Rezoning Petition Review – Charlotte Tree Ordinance

Subject: City of Charlotte – Urban Forestry Rezoning Petition Review Summary

Rezoning Petition # OR Pre-submittal meeting: 2021-082

RZ-1.0

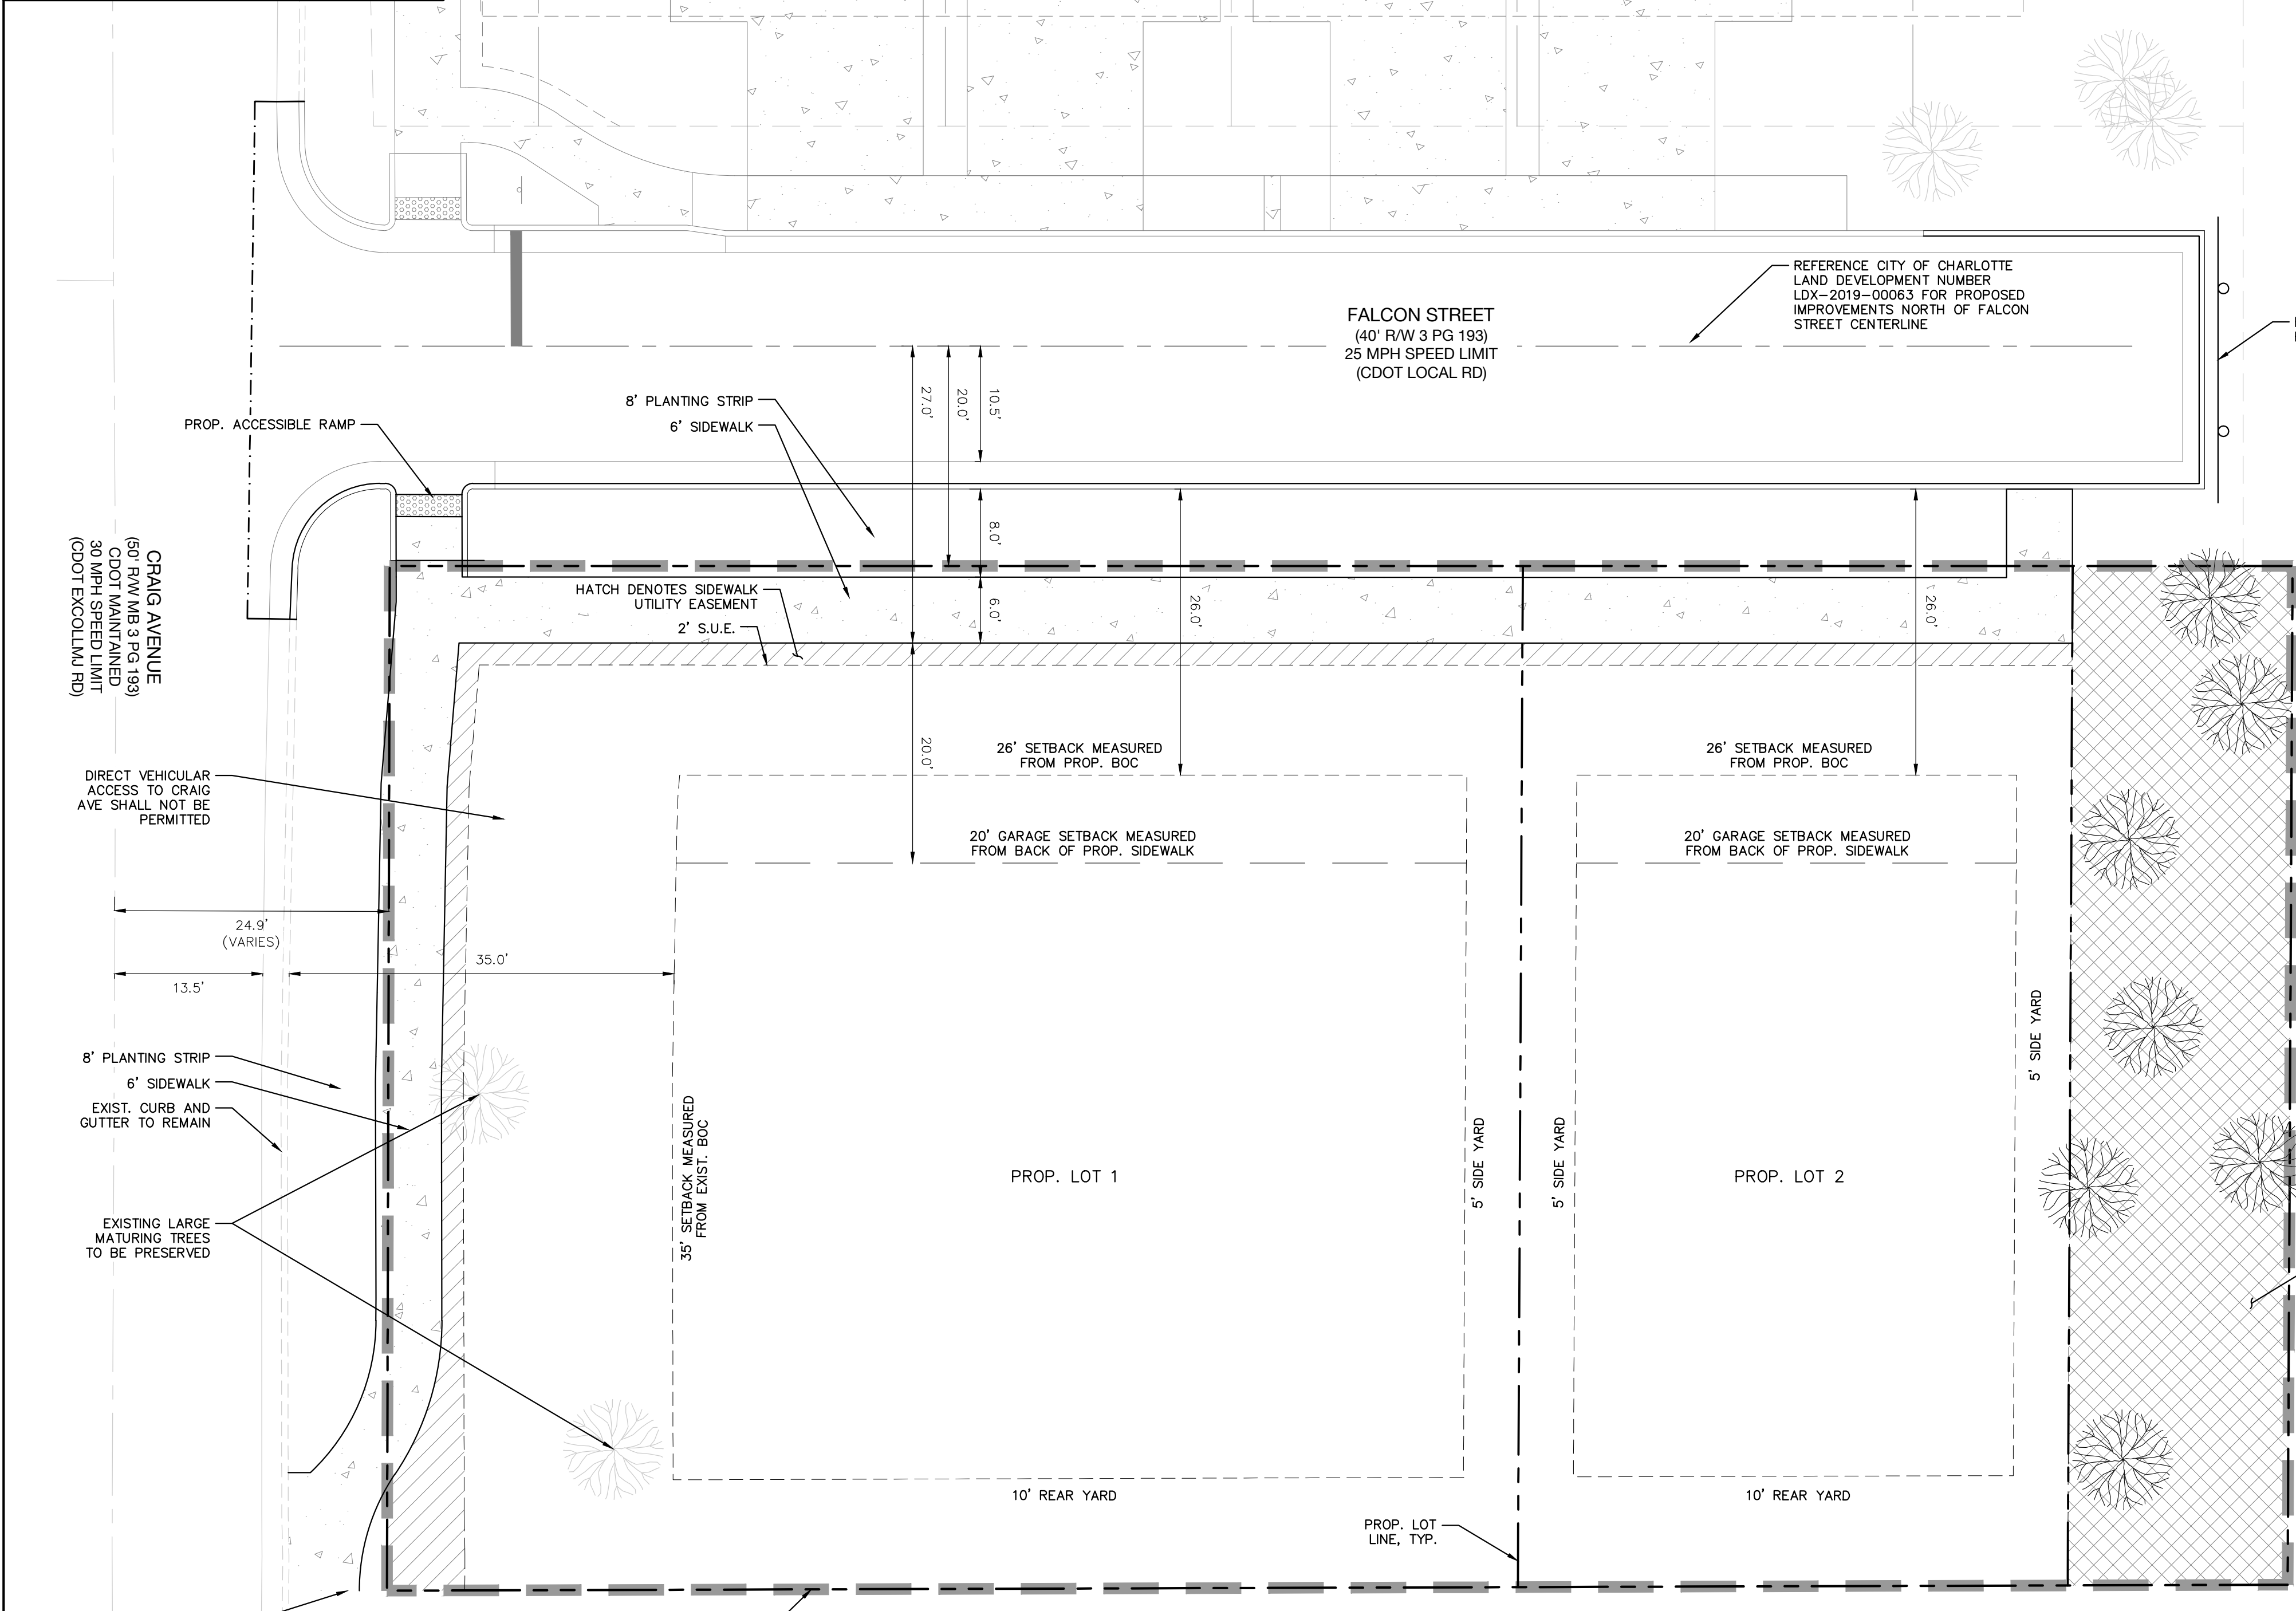
- A tree survey shall be submitted identifying all trees of eight-inch (8) dbh or greater and all planted trees of (2) two-inch caliper or greater and six feet in height that grow partially or wholly within public street right-of-way.

- All existing City street trees in public street right-of-way (City or State-maintained) are required to be preserved per the Charlotte Tree Ordinance and the following Tree Ordinance Guidelines: 1) City Trees & Protected Vegetation; 2) City Tree Mitigation Policy.

- Define potential on-site tree save areas and/or other option that will be utilized to meet Charlotte Tree Ordinance's commercial tree save requirement.

- Perimeter Trees: Street trees are required to be planted along all public roads per the Charlotte Tree Ordinance
 - o Small-mature tree species are required in locations where overhead distribution lines may impact natural tree growth.
- Internal Trees: Internal trees may be required to be planted in all surface parking lots and to mitigate impacts from impervious surfaces on-site.
